Project name	M25 Junction 28 improvements
File reference	TR010029
Status	Final
Author	The Planning Inspectorate (the Inspectorate)
Date	16 April 2020
Meeting with	Highways England (The Applicant)
Venue	Teleconference
Meeting objectives	Draft Documents feedback review and project update
Circulation	All attendees

Section 51 Advice regarding draft Application documents submitted by Highways England

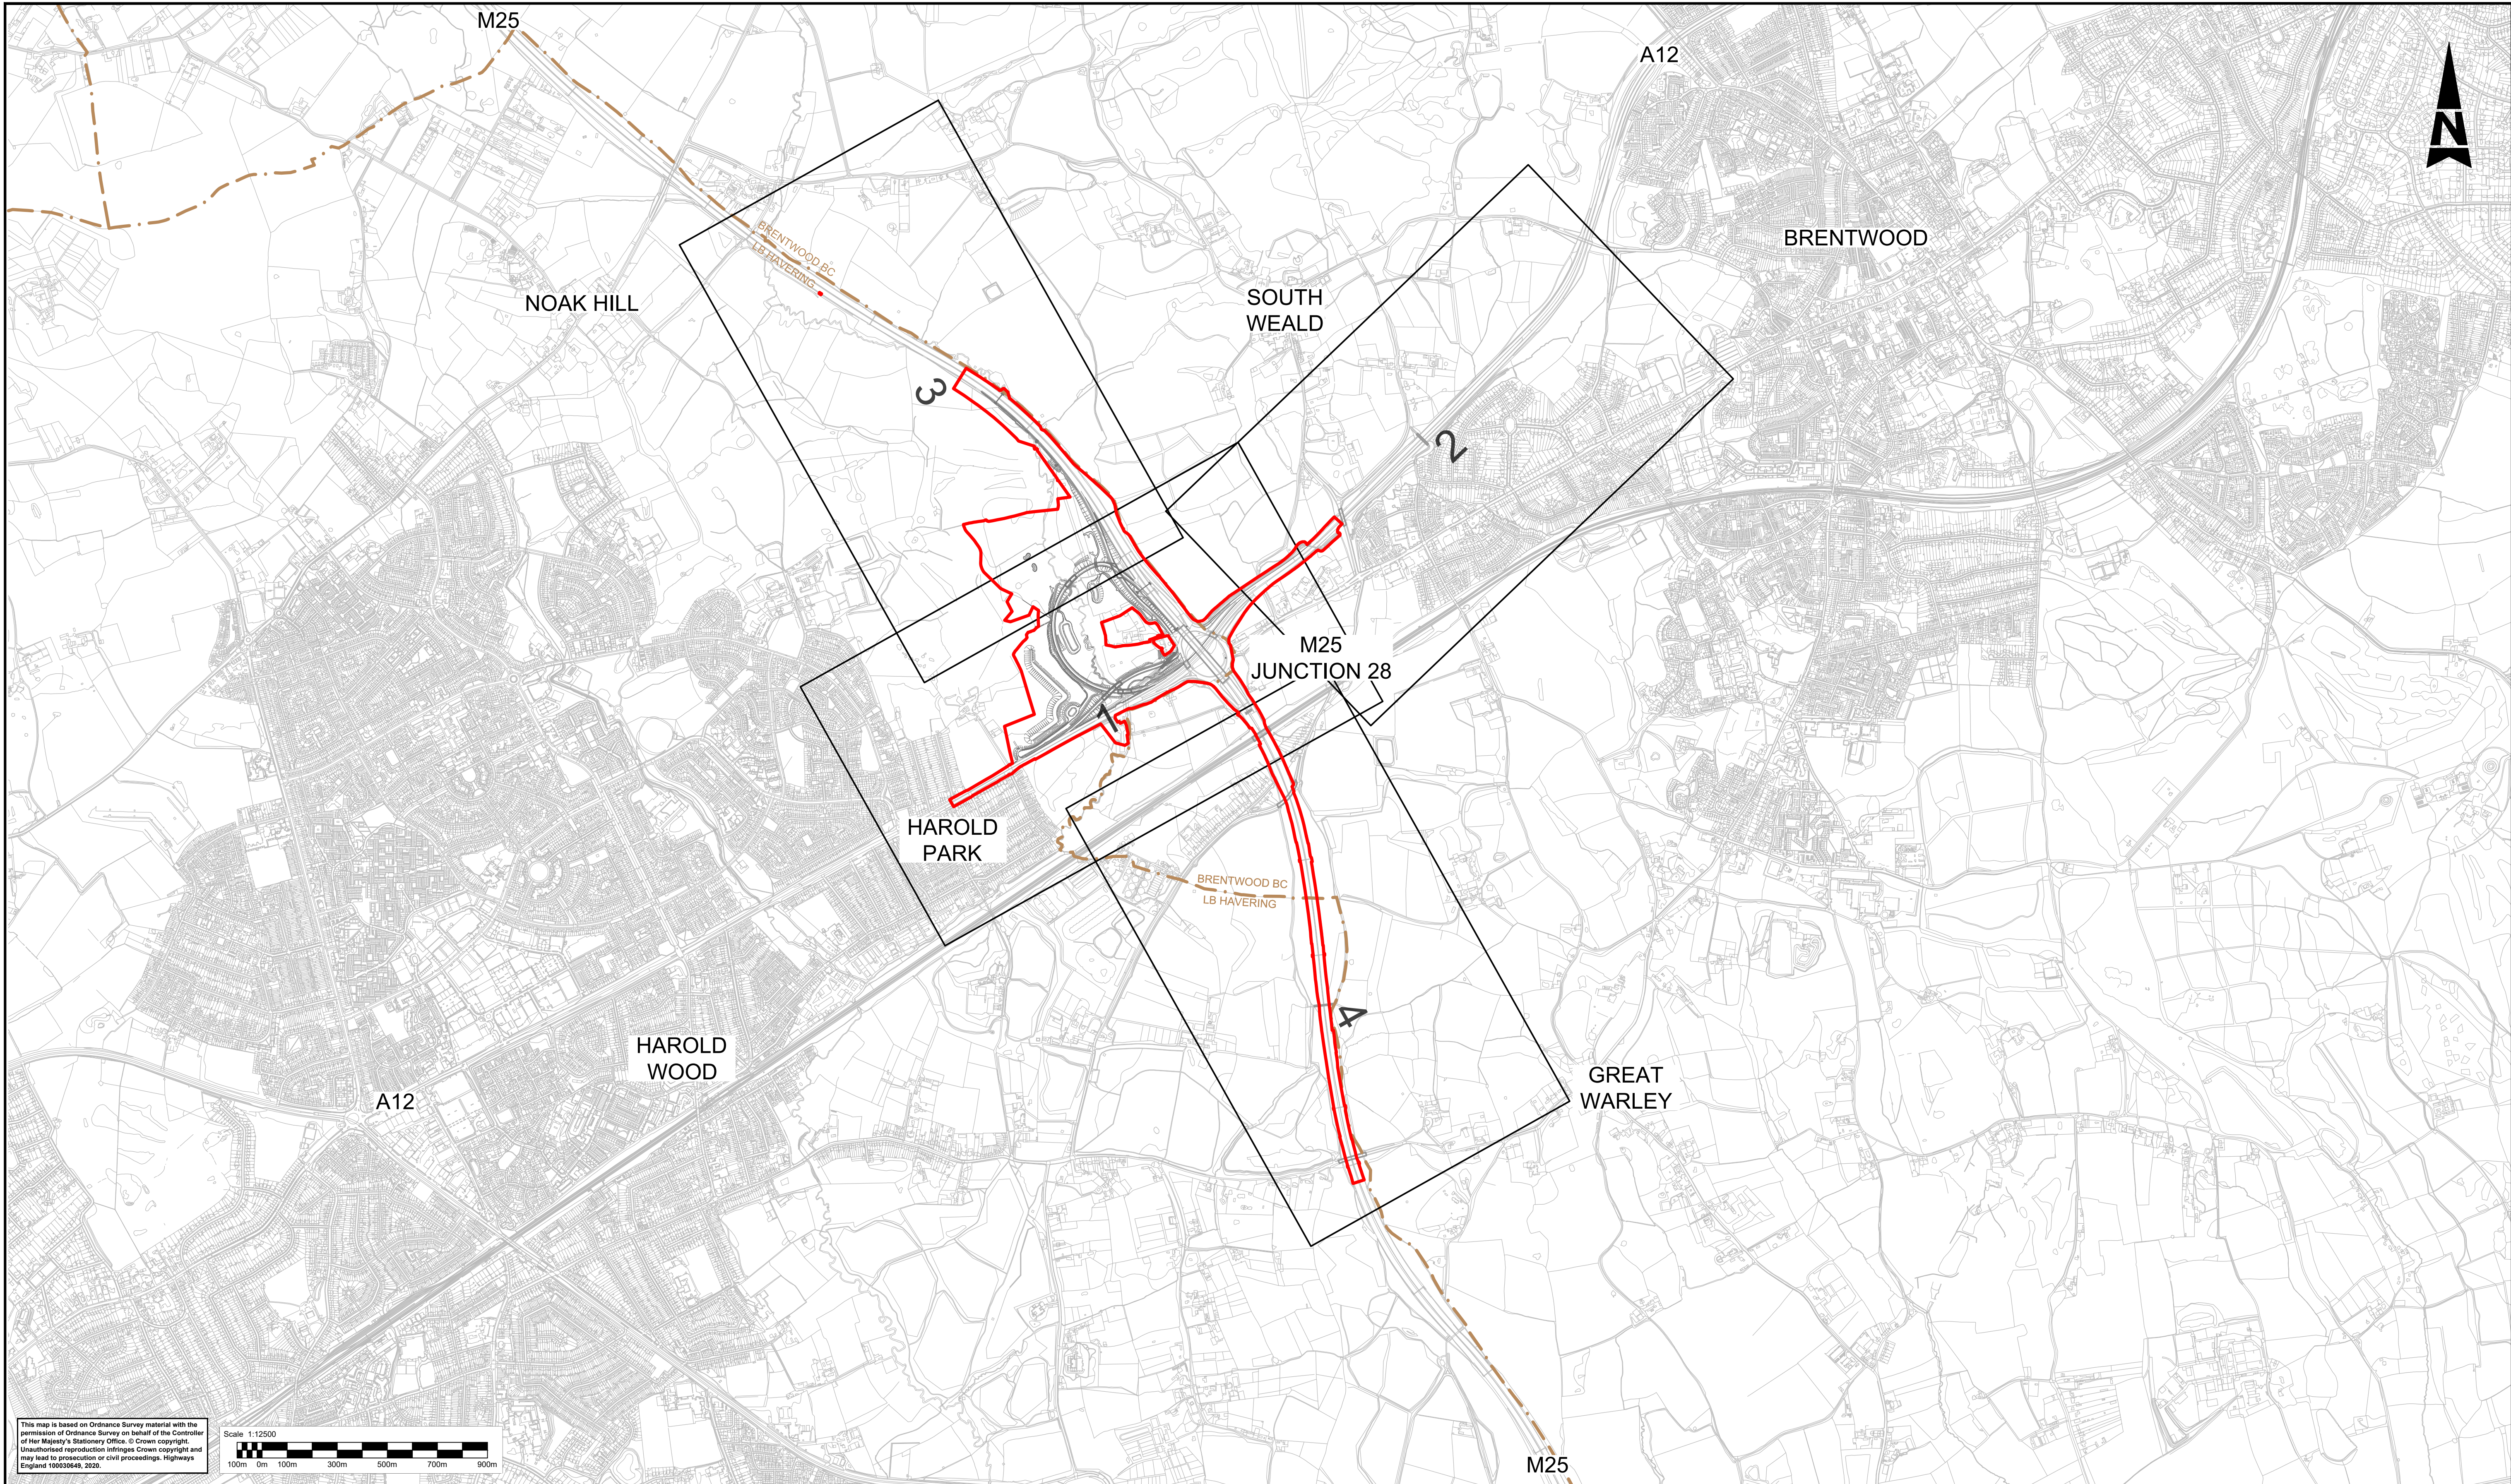
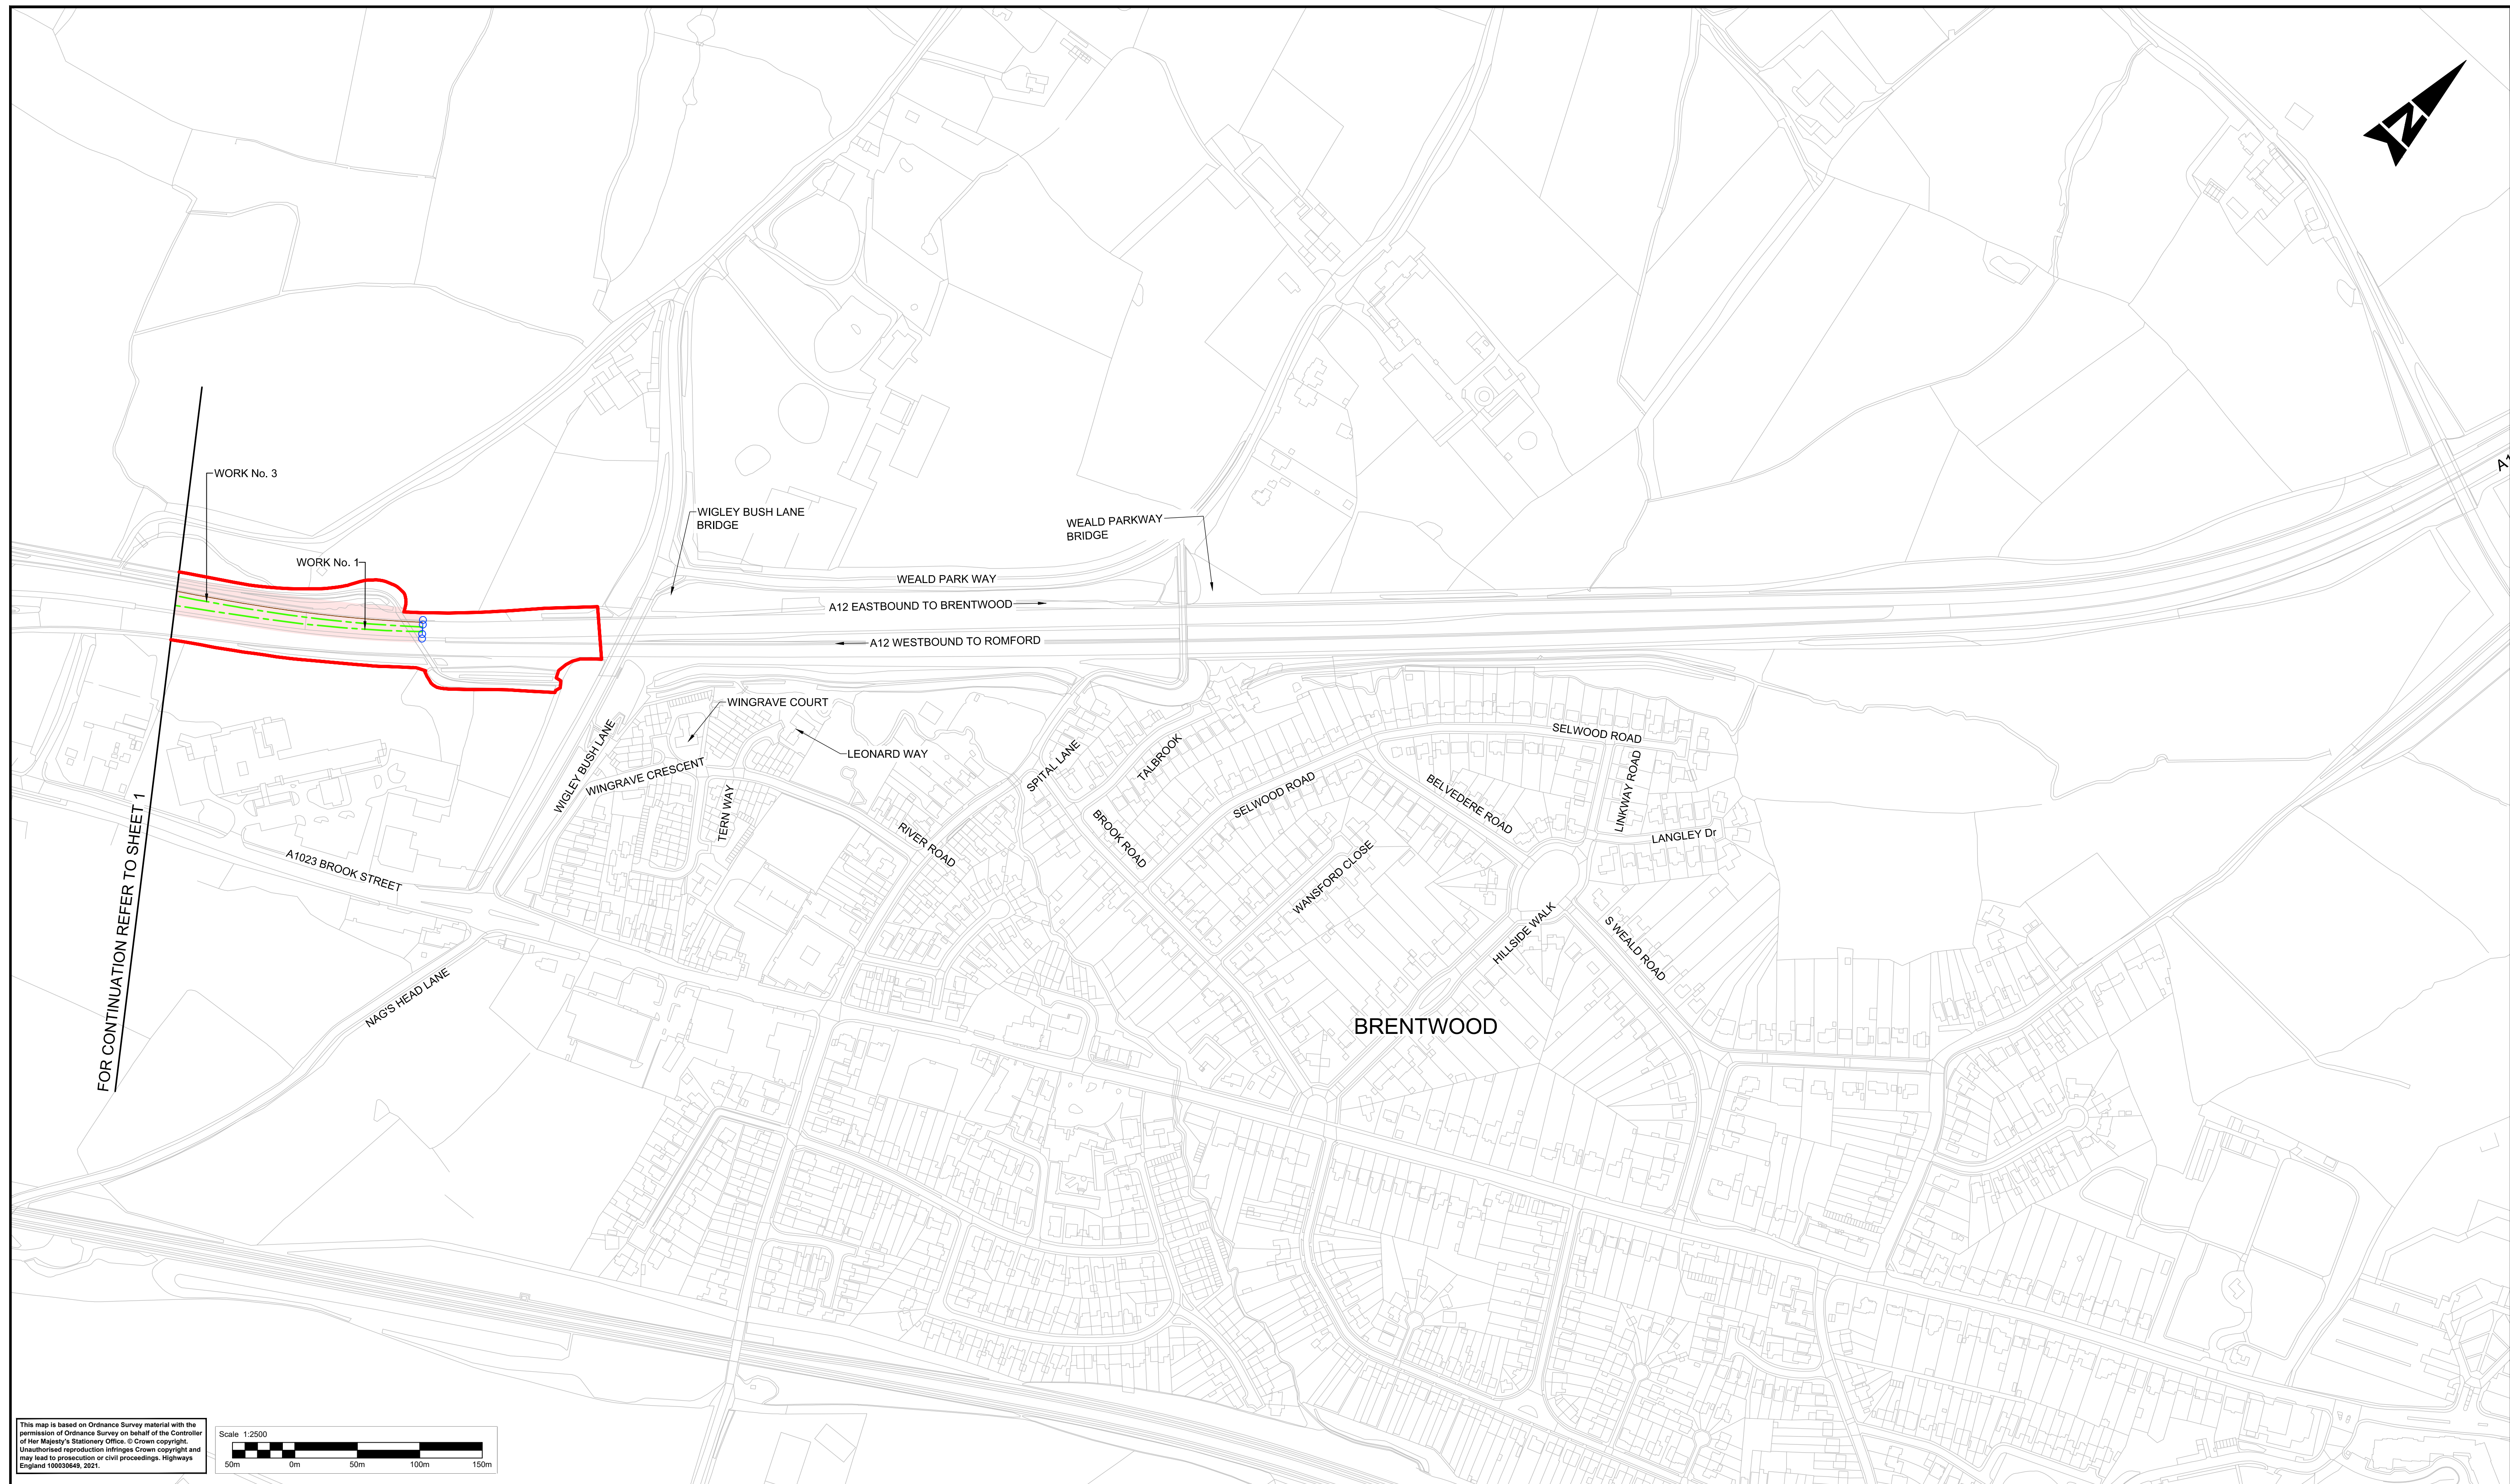
Draft Works Plans			
Ref No.	Work Plan Ref	Extract from Schedule 1: Authorised Development (PART 1)	Comment/Question
12.	Sheet 1	Work No. 17 – <i>A new private means of access approximately 475 metres in length, commencing at a point situated approximately 100 metres north of the existing Grove Farm access, passing through the proposed Grove Farm Underpass (Work No. 6) and terminating approximately 125 metres north of Grove Farm Underpass, as shown on sheets 1 and 3 of the Works Plans.</i>	Work 17 on Sheet 1 seems to start north of the existing Grove Farm access, comes south, passing through the underpass and finishes south onto the m25 northbound on-slip. The description has it finishing 125 metres north of the grove farm underpass; the Applicant may wish to consider the depiction on the plan or the description.
